**SECTION 75W MODIFICATION APPLICATION TO MP10_0230
WOOLLOOWARE BAY TOWN CENTRE**

This Section 75W Modification has been prepared to modify the Project Approval MP10_0230 for the Retail/Club Precinct at 461 Captain Cook Drive, Woollooware (Woollooware Bay Town Centre). It is submitted to the Minister for Planning and Infrastructure (or his delegate) pursuant to section 75W and Clause 12 of Schedule 6A of the *Environmental Planning and Assessment Act, 1979* (EP&A Act) by JBA on behalf of Bluestone Capital Ventures No. 1 Pty Ltd (Bluestone).

This modification application relates to minor design modifications to the approved Stage 1 Retail/Club development. Proposed amendments include minor design refinements to the retail development and amended stratum subdivision plans in response to the detailed design of the approved development.

PLAN OF SUBDIVISION OF LOTS 1 & 2
IN DP1180482

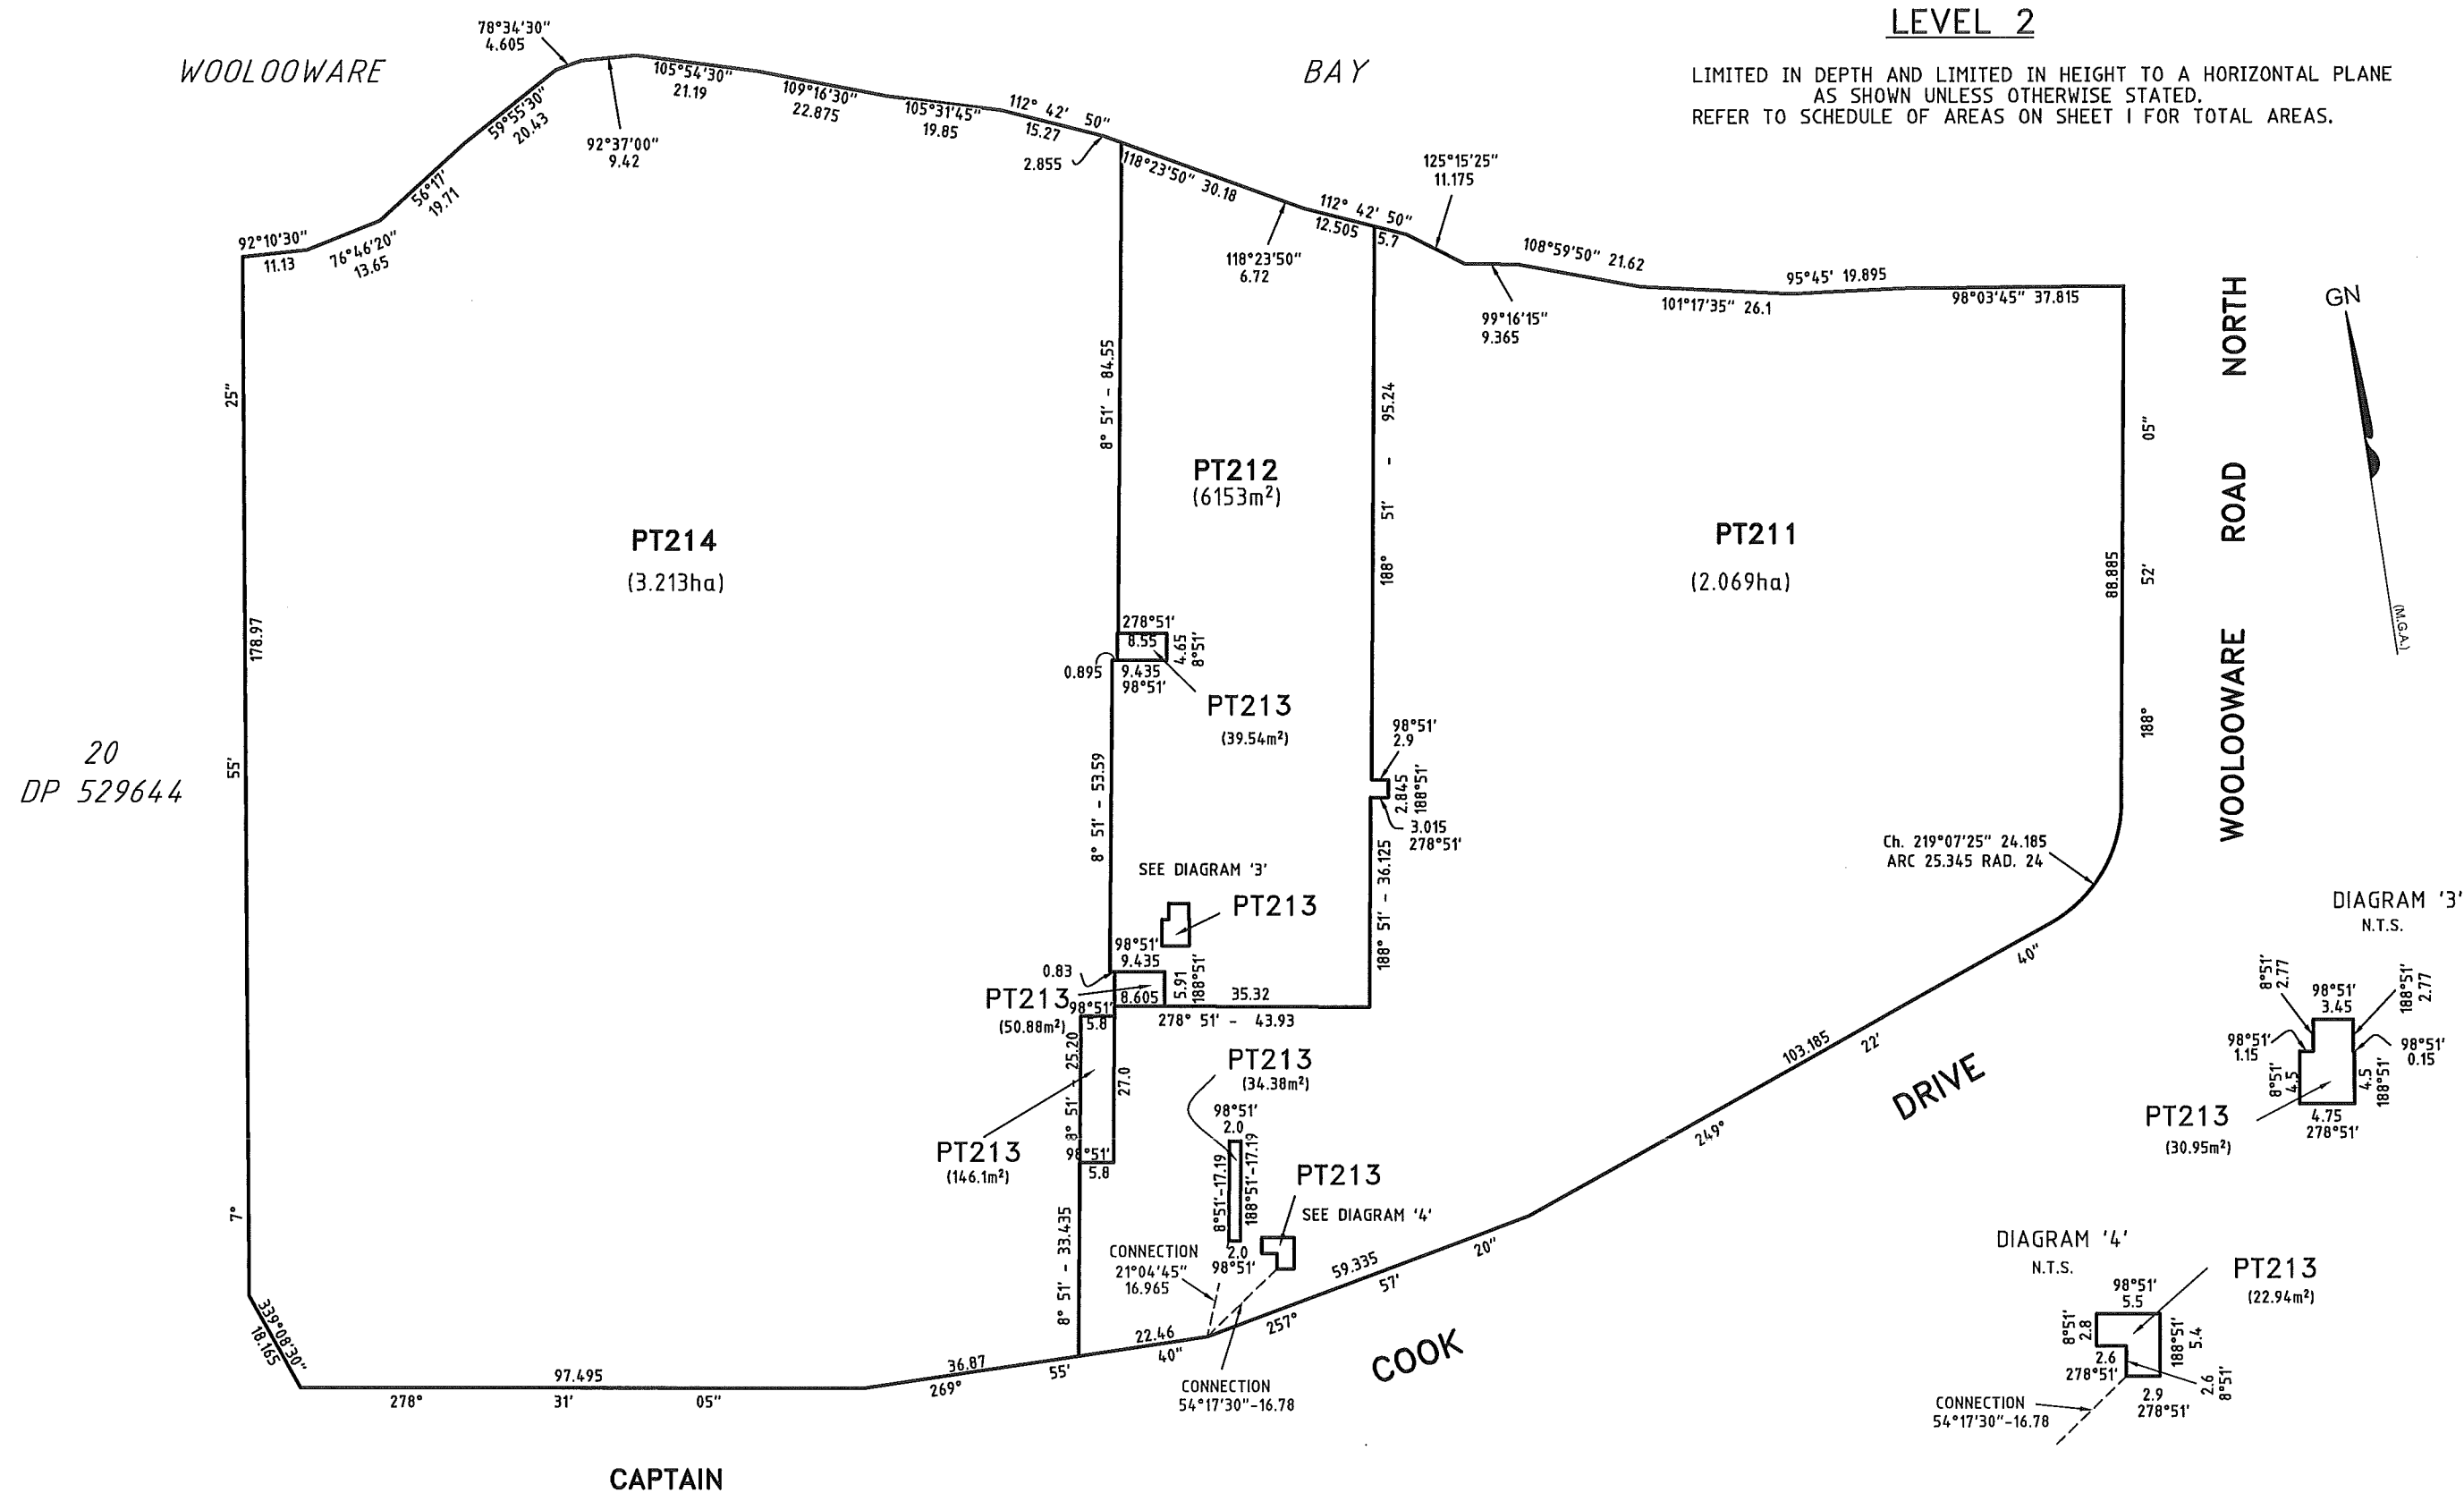
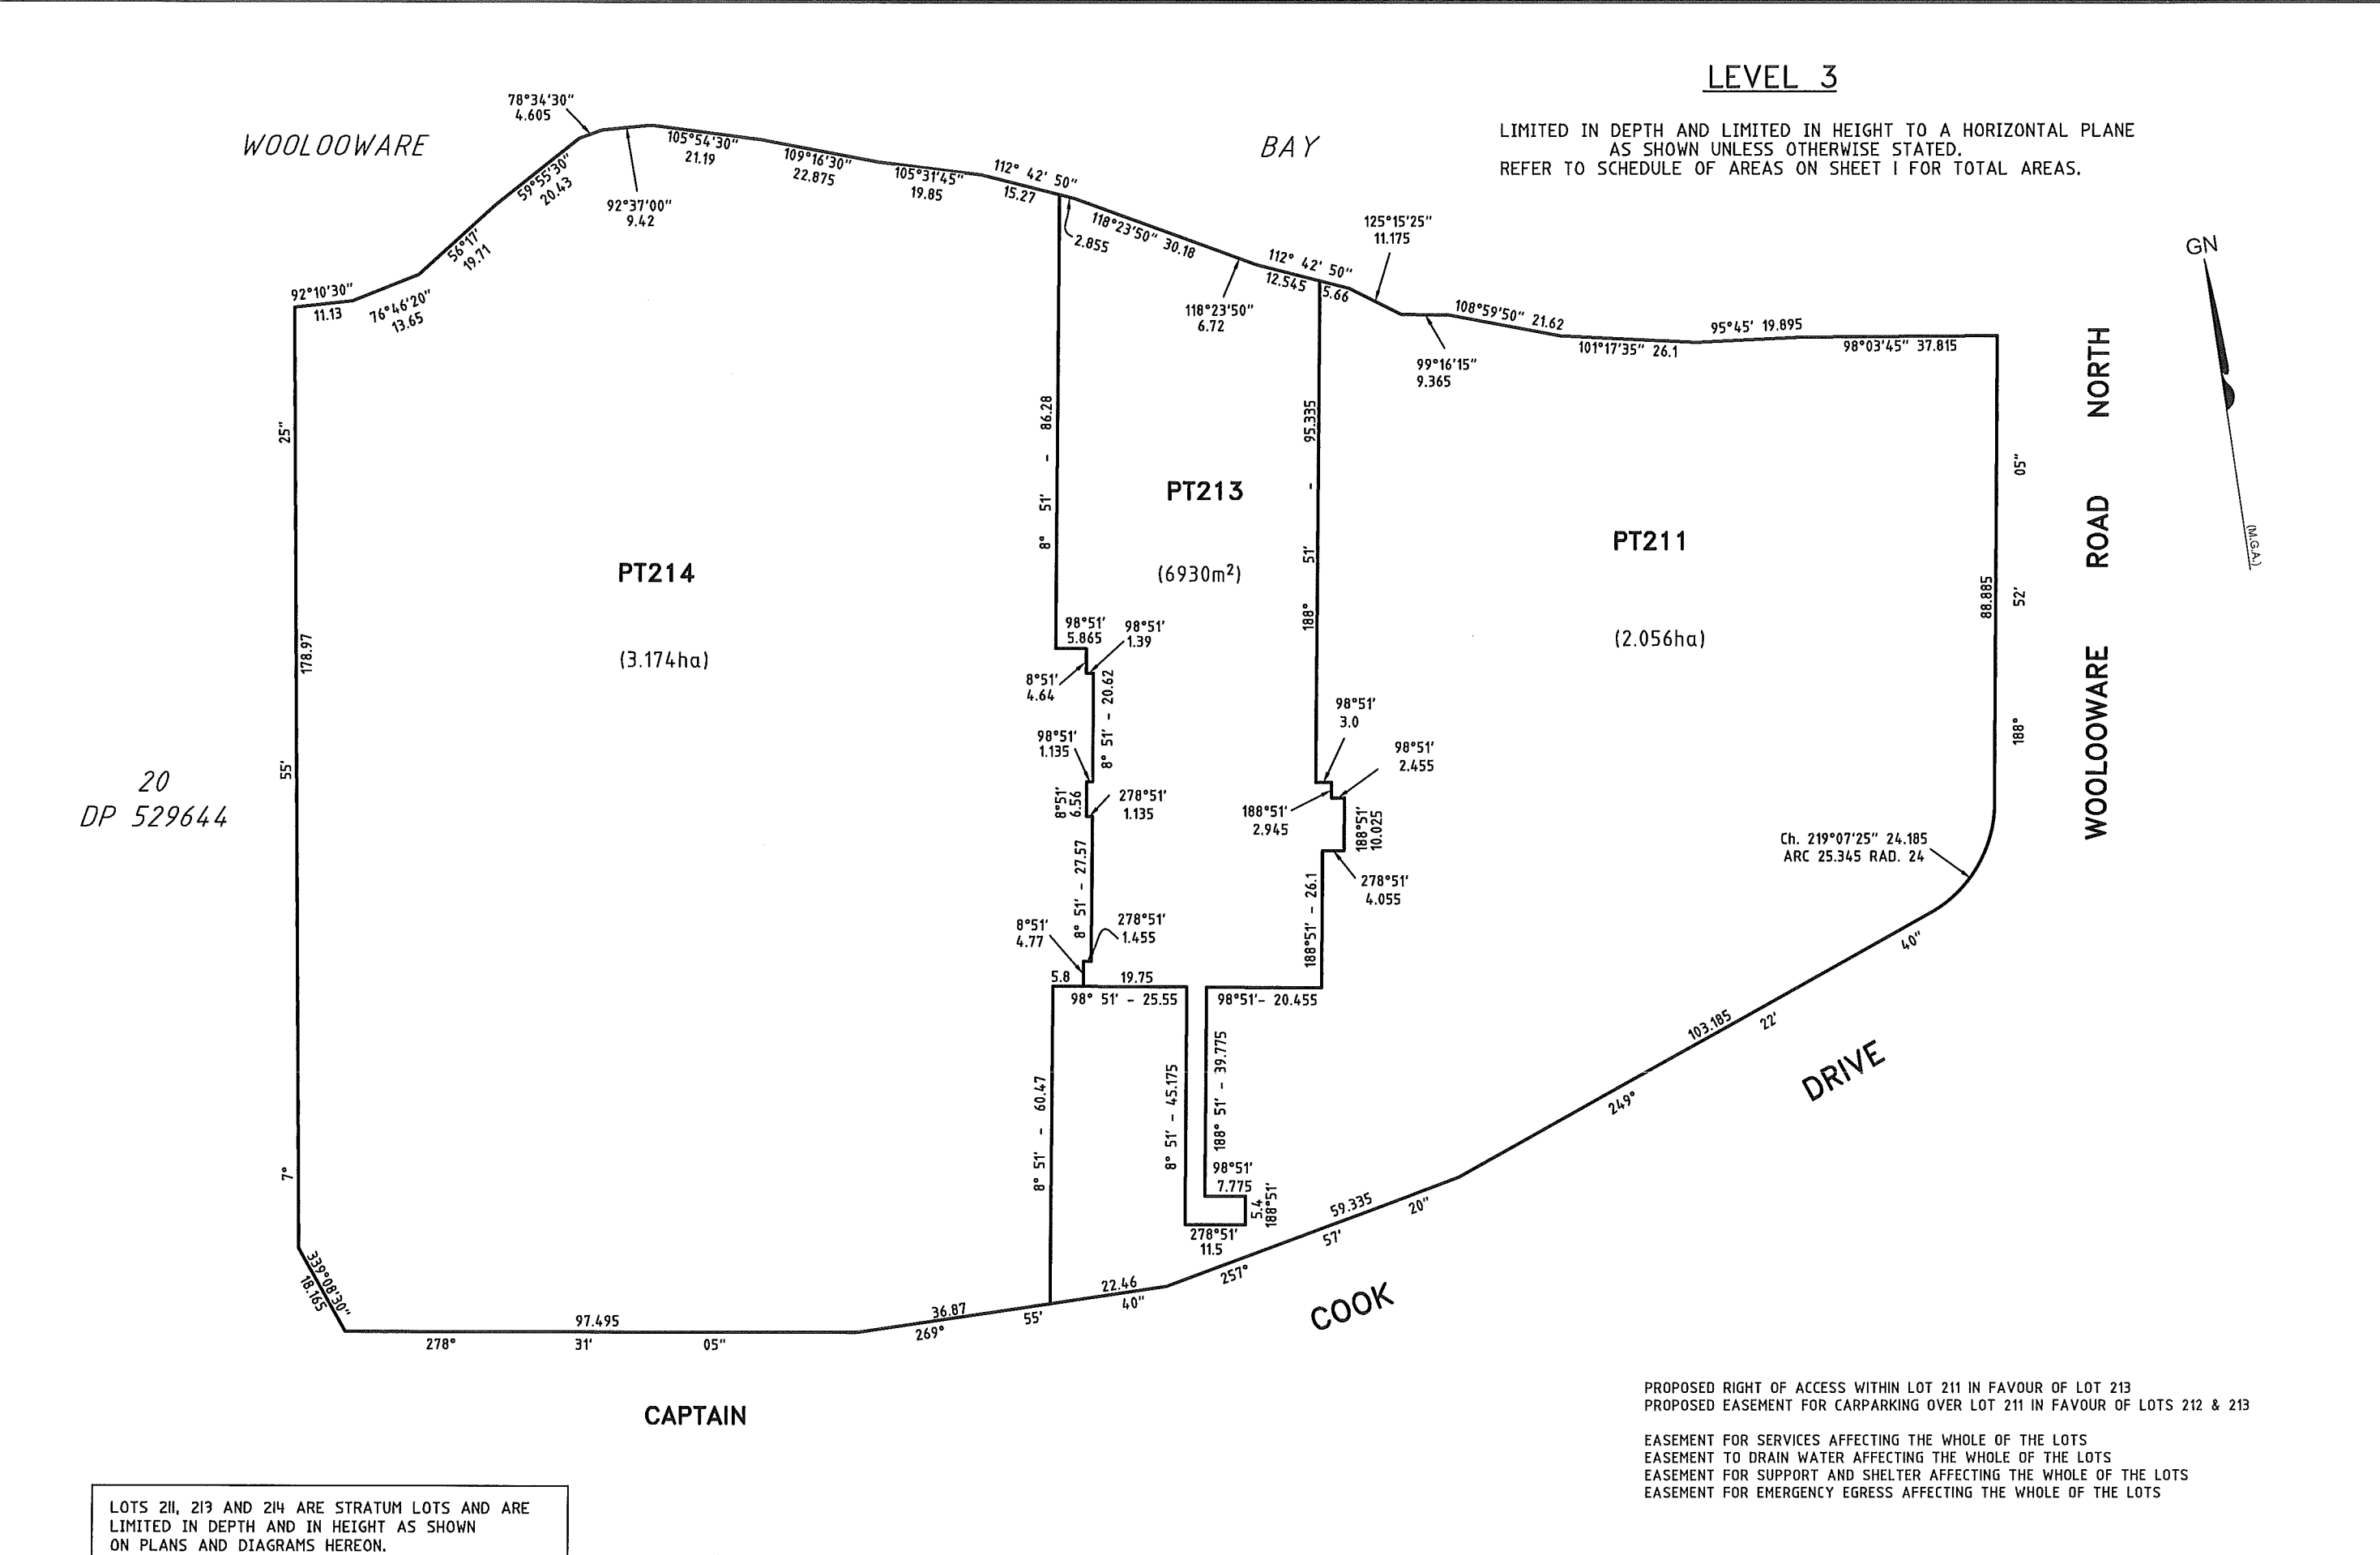
The Project Approval granted consent for the stratum subdivision of several lots in DP1180482 to facilitate the future use of the development. Due to the detailed design development of the approved scheme and the changes set out in the Amended Architectural Plans (**Attachment A**), minor boundary adjustments have occurred which has necessitated updated stratum subdivision plans. The Subdivision Plans prepared by Harrison Friedmann & Associates are provided at **Attachment B**.
